FW: D2134/86 - LU-193-25-PL – Courtwick Park

Application No: LU/193/25/PL

Site Address: Court Wick Park Courtwick Lane Littlehampton BN17 7PD

Description of Works: Proposed residential development for 4 houses and associated landscaping. This application may affect the setting of a Listed Building and is in CIL Zone 2 (CIL liable as new dwellings).

Outfall Manhole PLOT 3 SOAKAWAY : Infiltration Tank

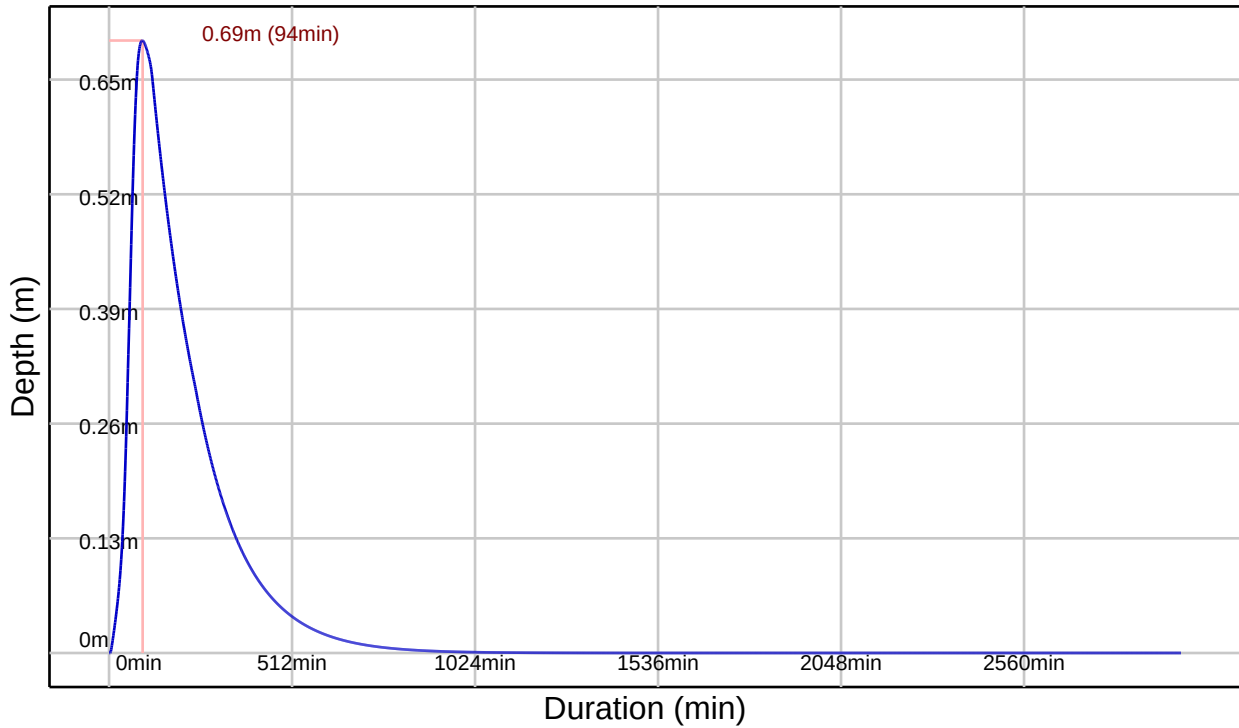
- There may be an issue with plot 4 soakaway if it gets larger
- There may be an issue with plot 3 soakaway if it gets larger
- There are 3 larger trees where the 'orange' conflicts with the road footprint. Some areas are shown to be 'cellweb' but not all. These need to be checked as they may affect the 'road elevation' and 'permeable pavement' storage.
